Recommendation Report for Planning Permission

REF NO: LU/284/20/PL

LOCATION: 54 Arundel Road
Littlehampton
BN17 7DD

PROPOSAL: Demolition of 3 No. garages & erection of a four-room house of multiple occupation with shared facilities & parking for 3 cars (resubmission of LU/125/19/PL).

GROUND FLOOR PLAN PROPOSED

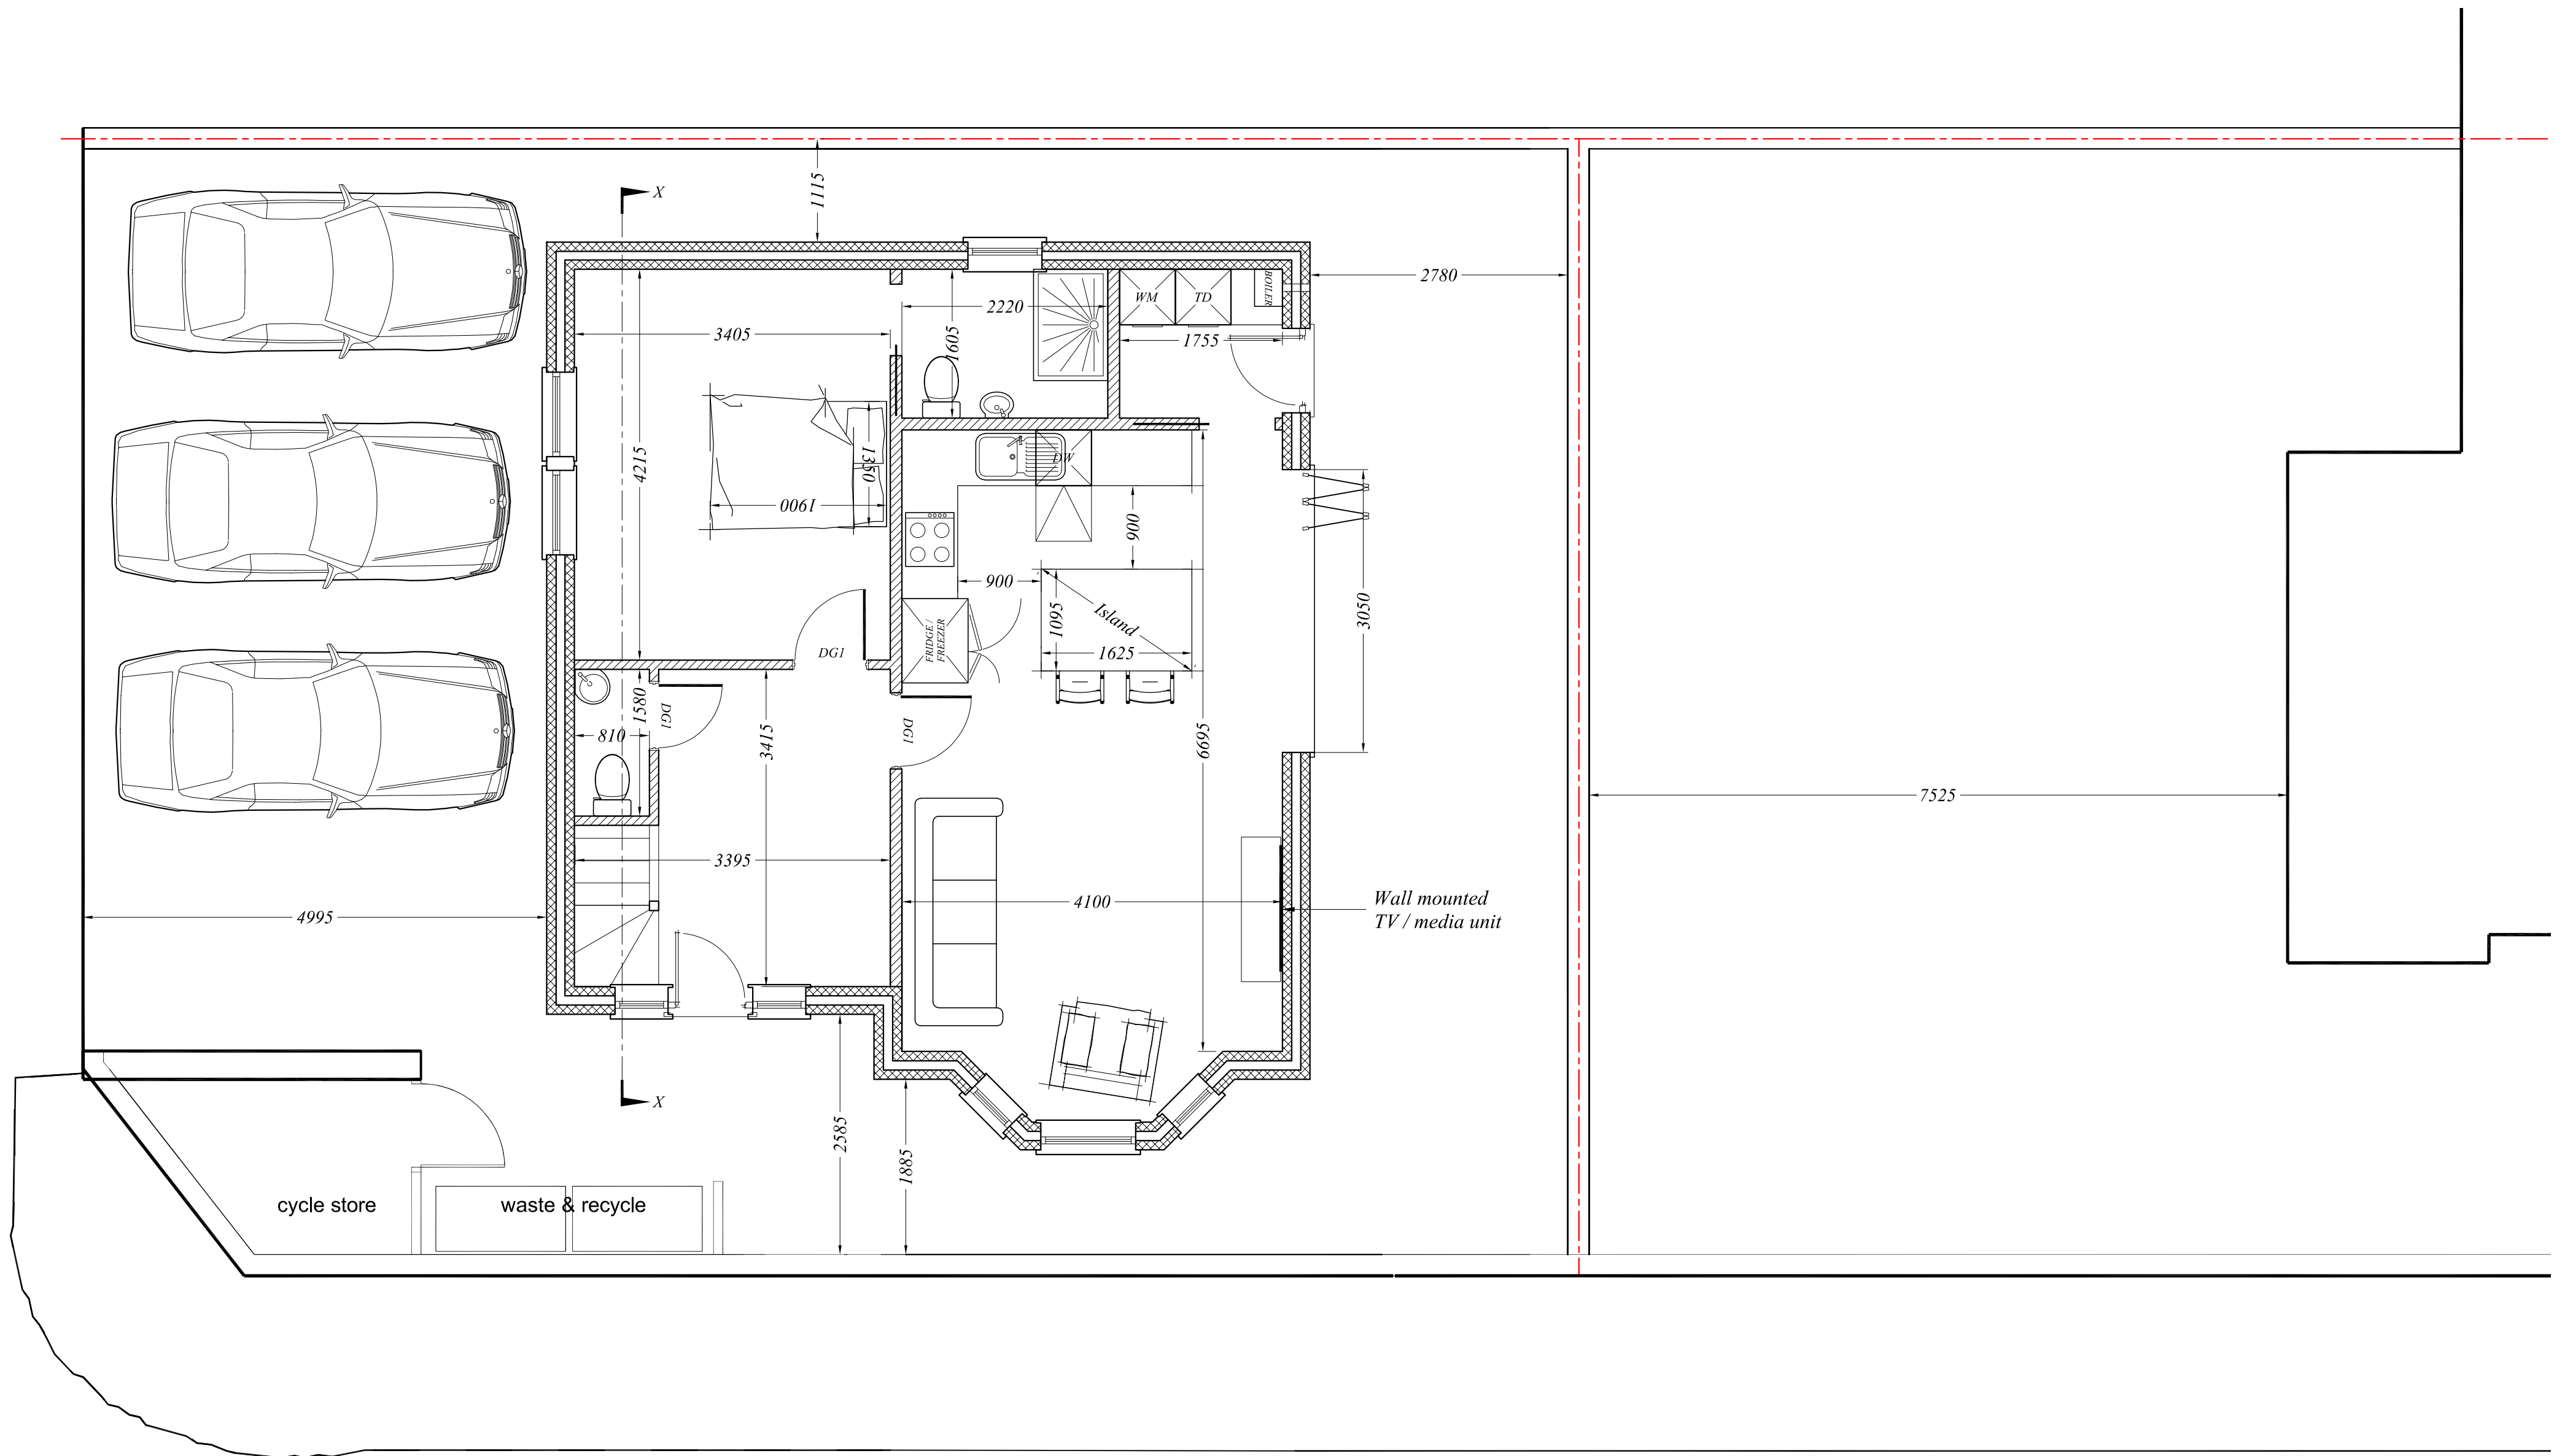
The proposed property would have a kitchen/diner room window at ground floor level which would face a 2 metre boundary wall at a distance of 2.5 metres which would cause a poor level of light and an overbearing impact on those primary habitable room windows.

FRONT (NORTH) ELEVATION

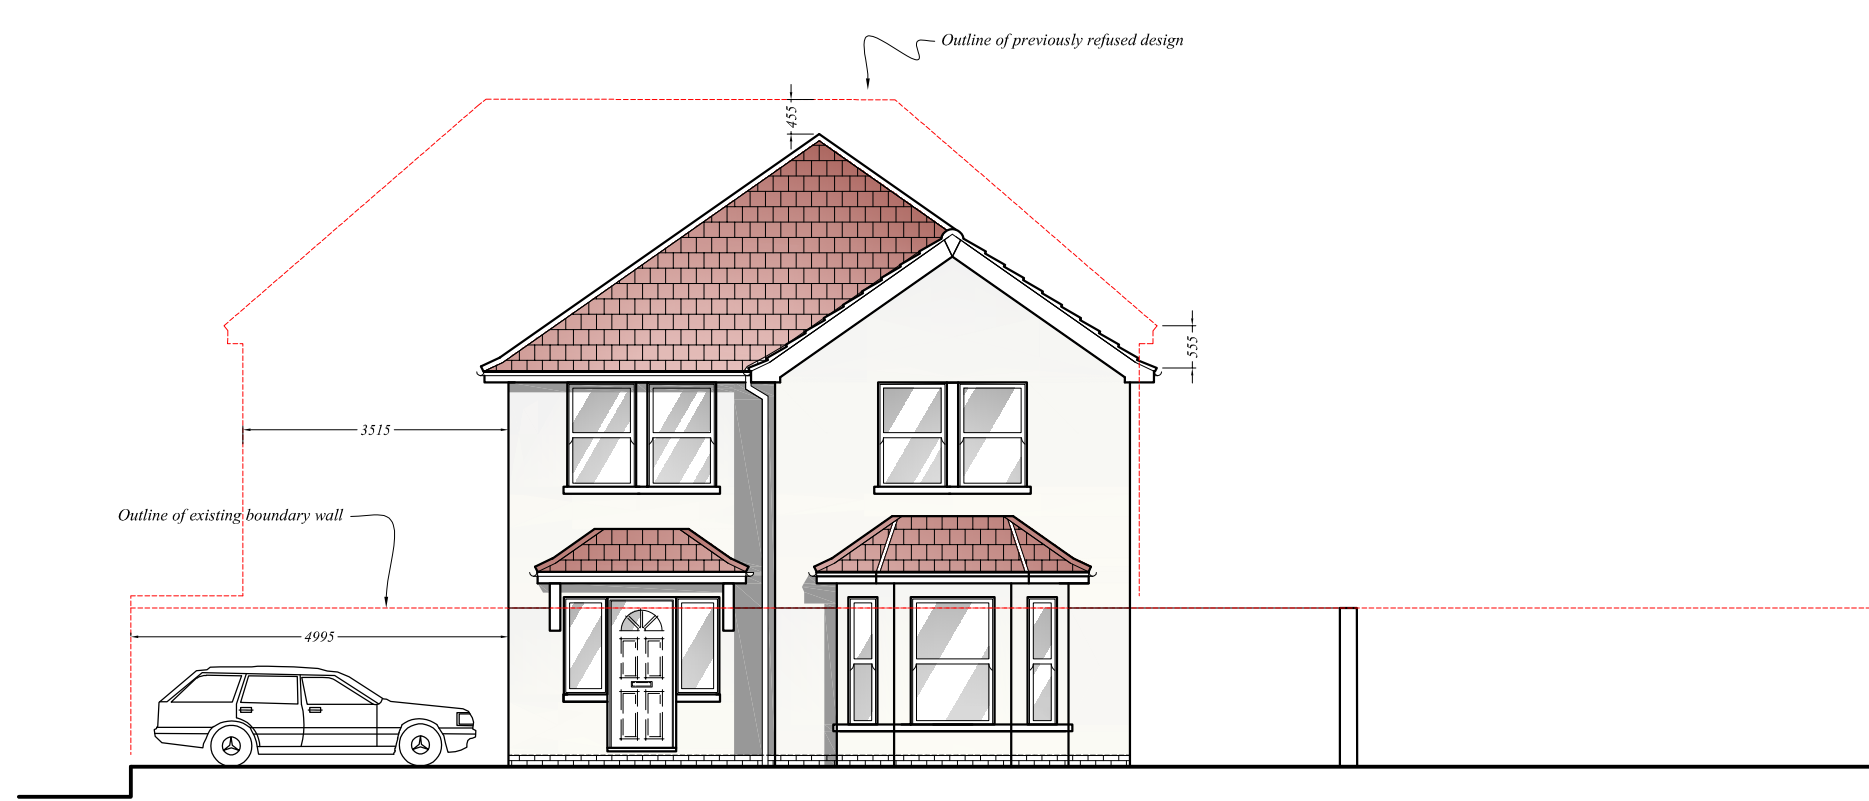
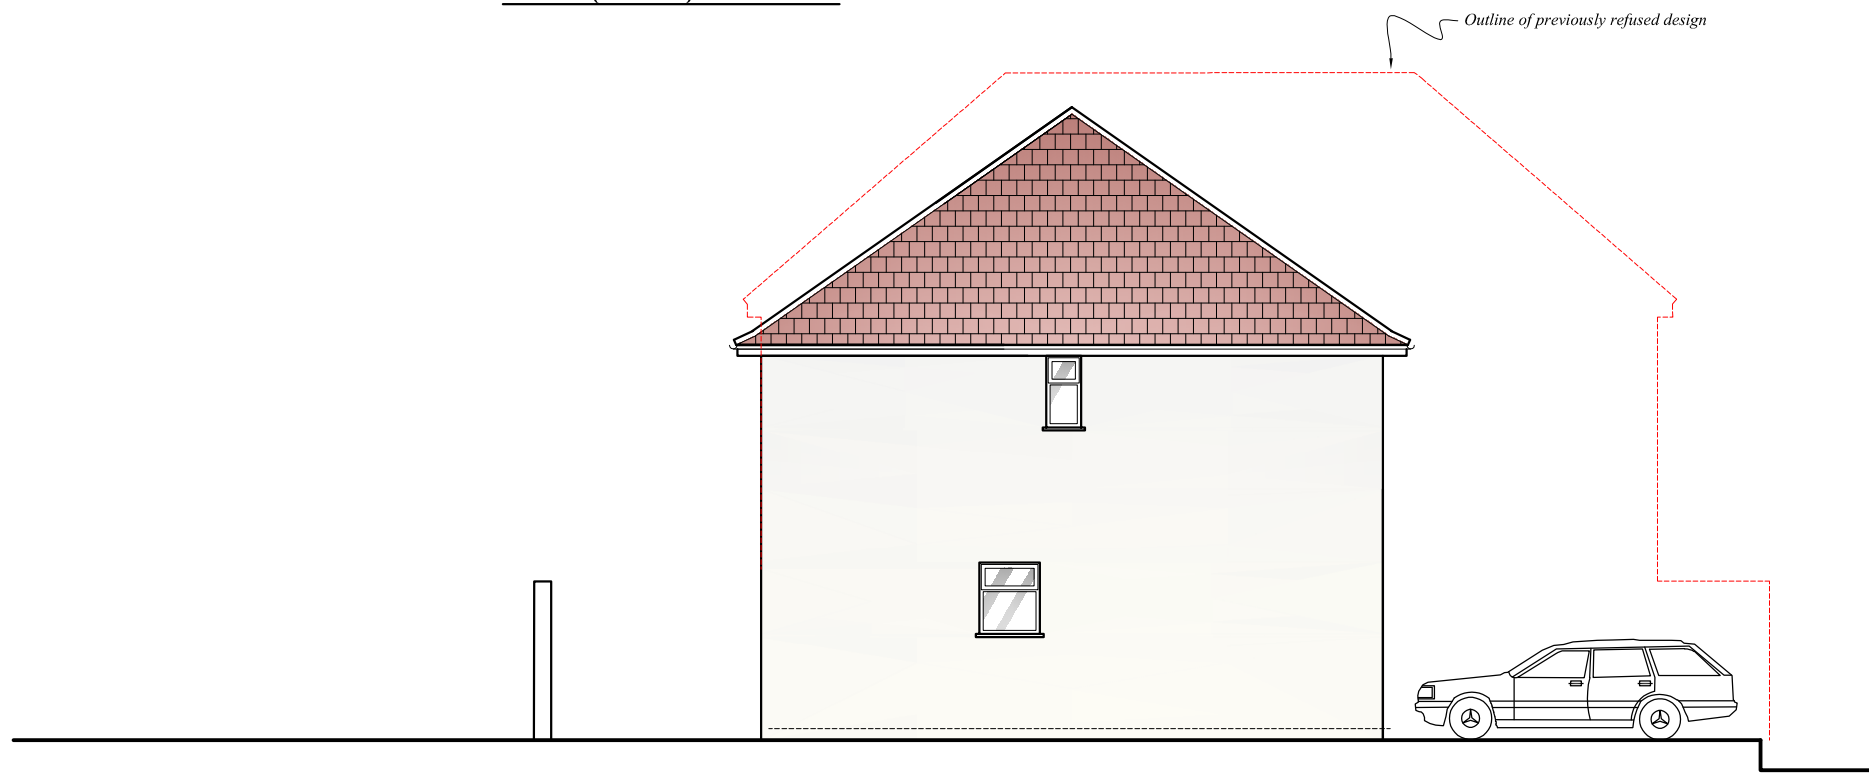
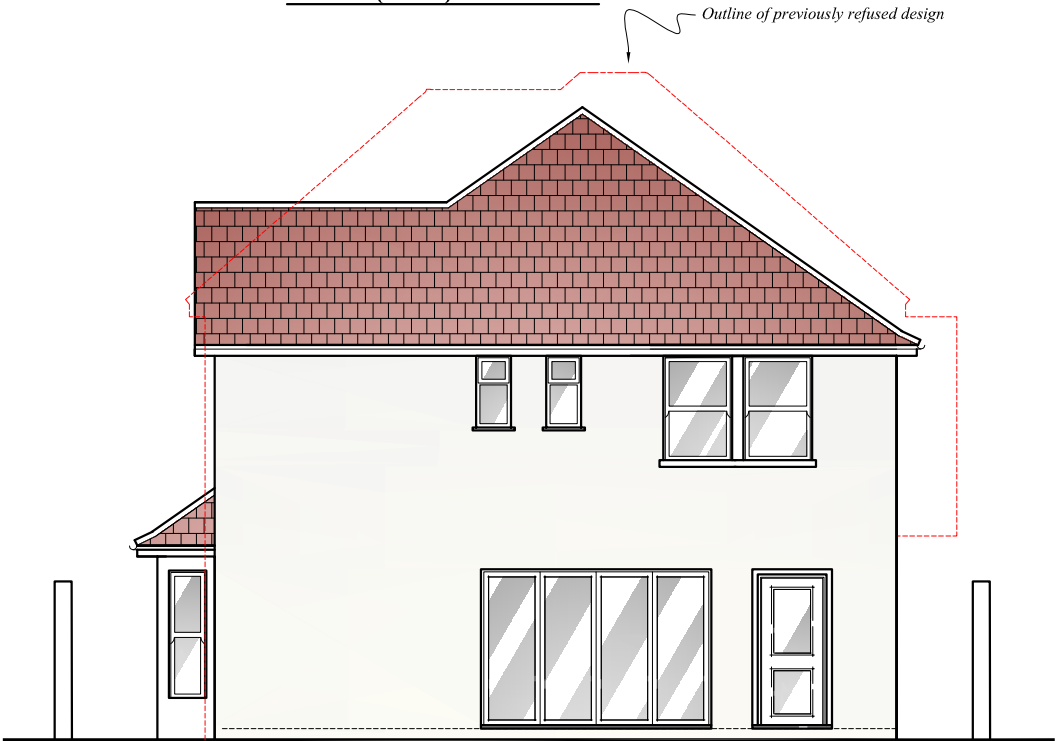
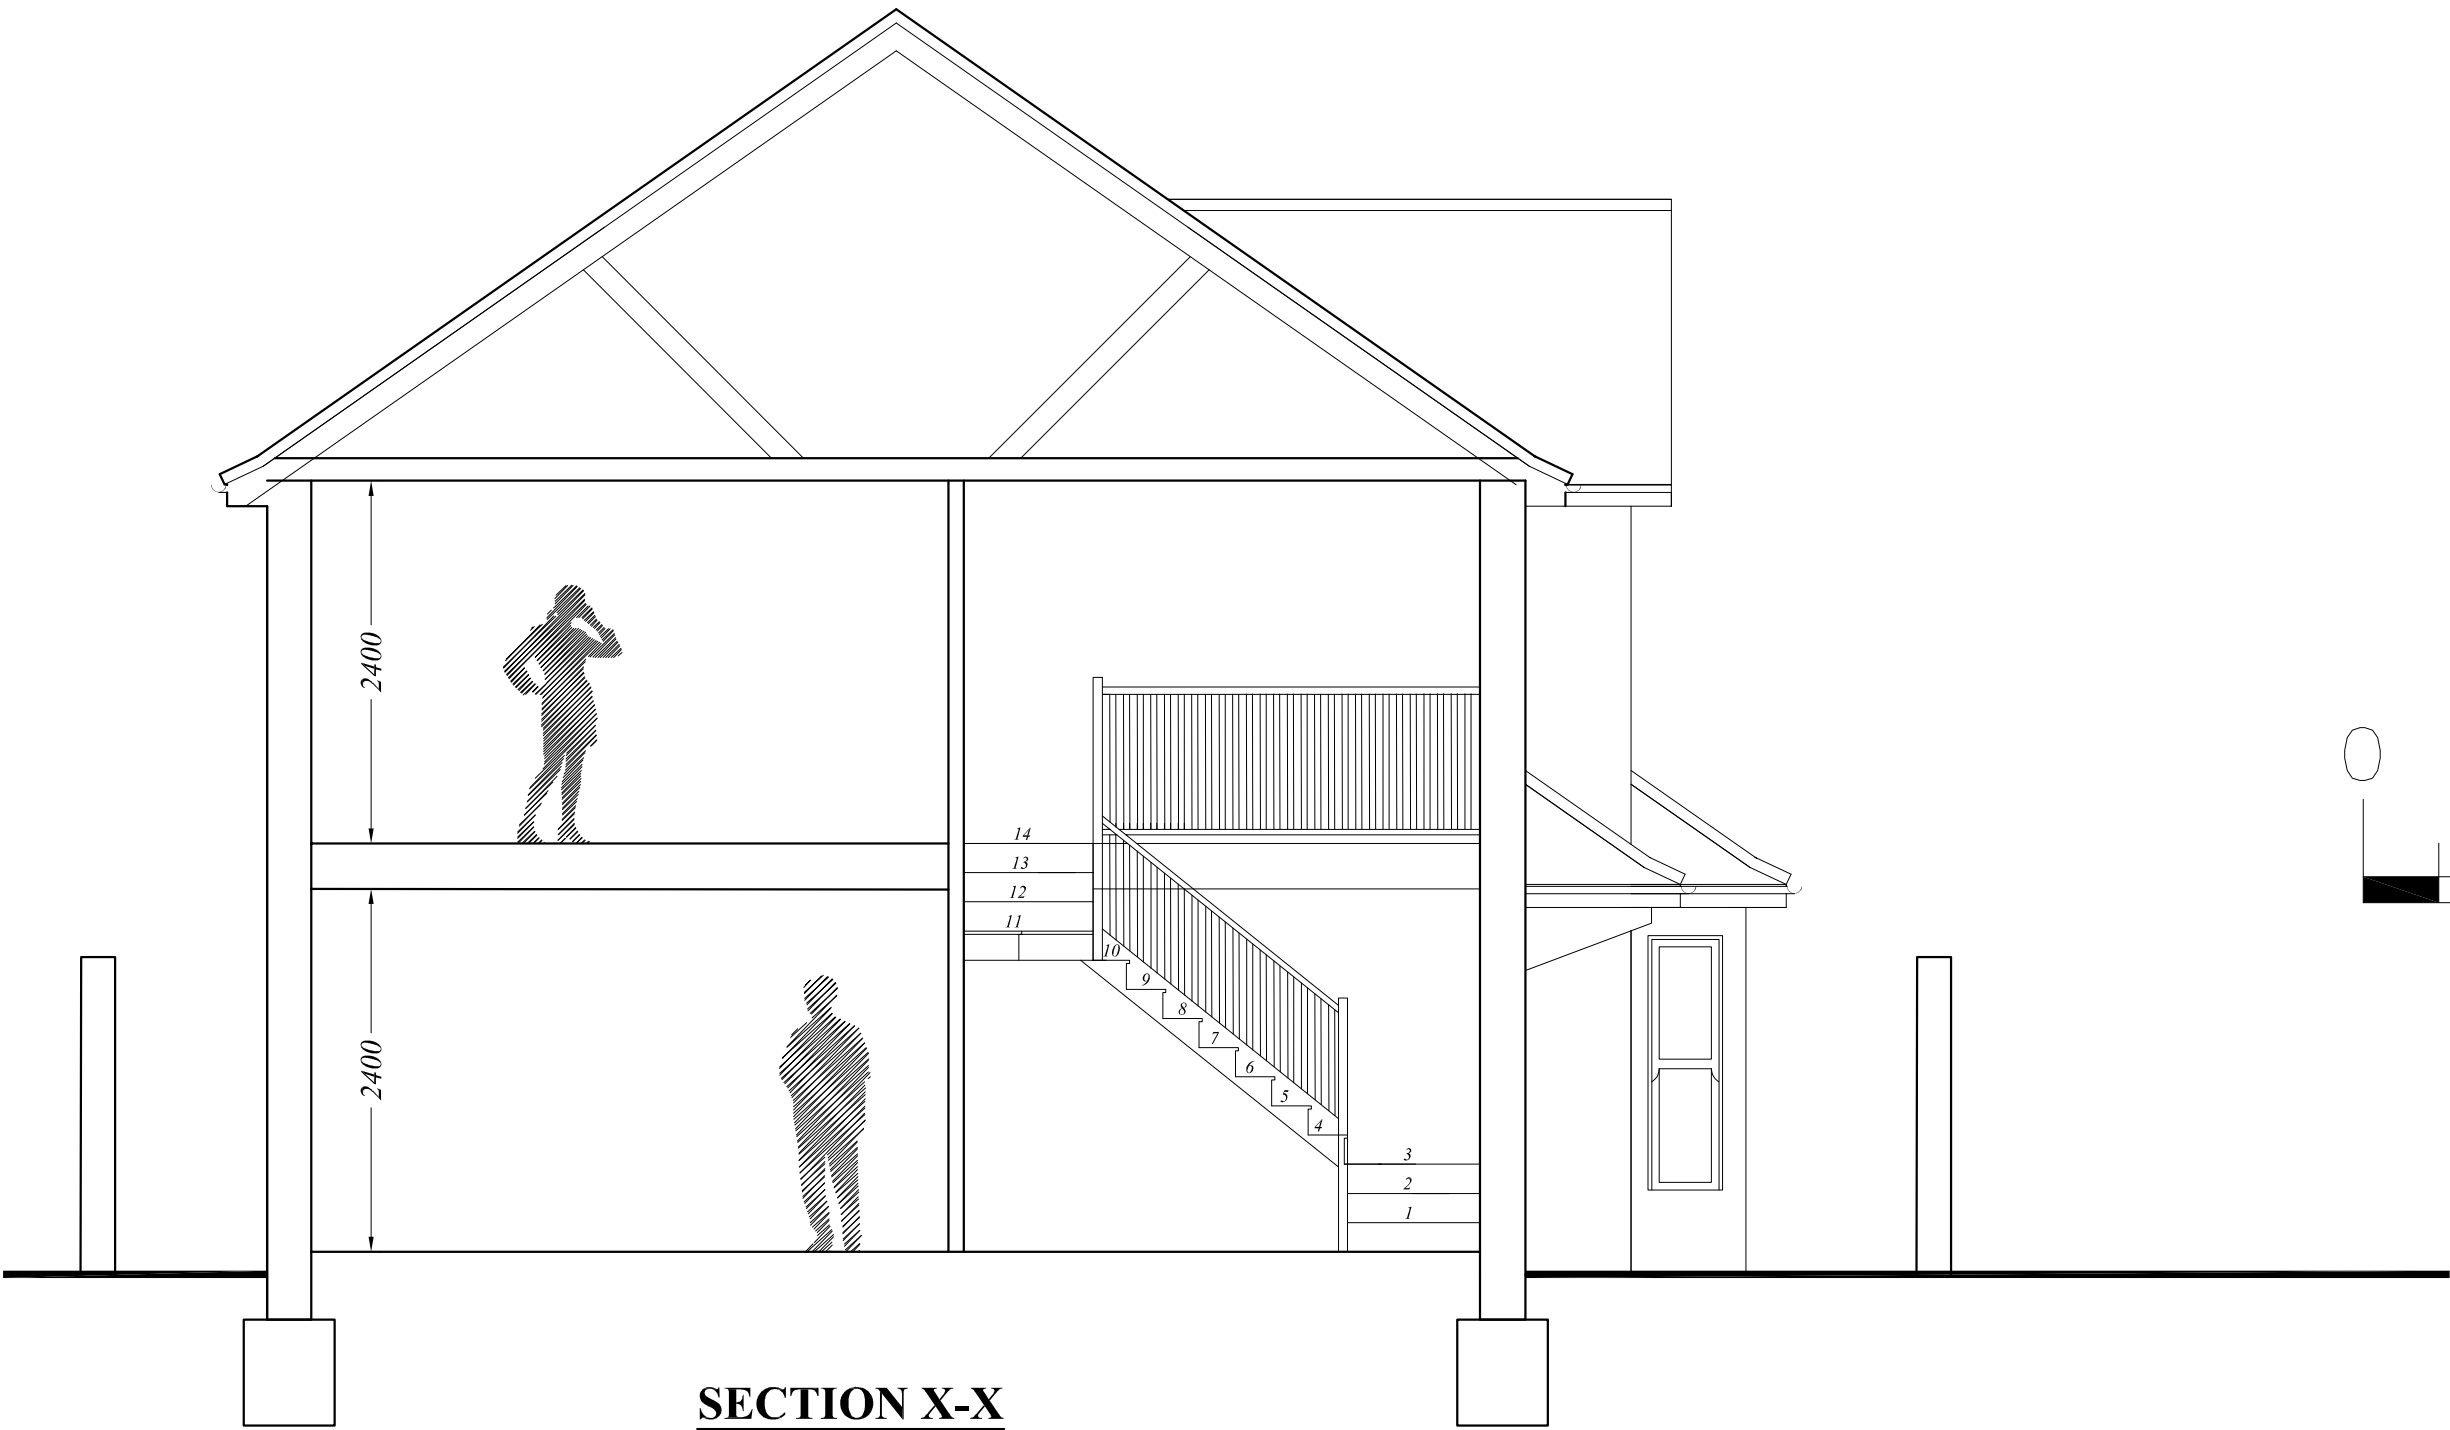
The proposed property would be a large building located on a small plot with very little space surrounding it. A 3.6 metre front garden is the only external space being provided which when taking into account the excessive scale of the proposal when viewed from the street scene, would lead to an overly cramped appearance.

The rear windows of 52 and 54 Arundel Road would likewise be impacted as a result of the 8.4 metre height and mass of the new building causing an overbearing impact and loss of light as well as a loss of privacy from primary windows in the new build which would be 10 metres distant between facing primary habitable room windows where a distance of 20 metres would normally be expected.
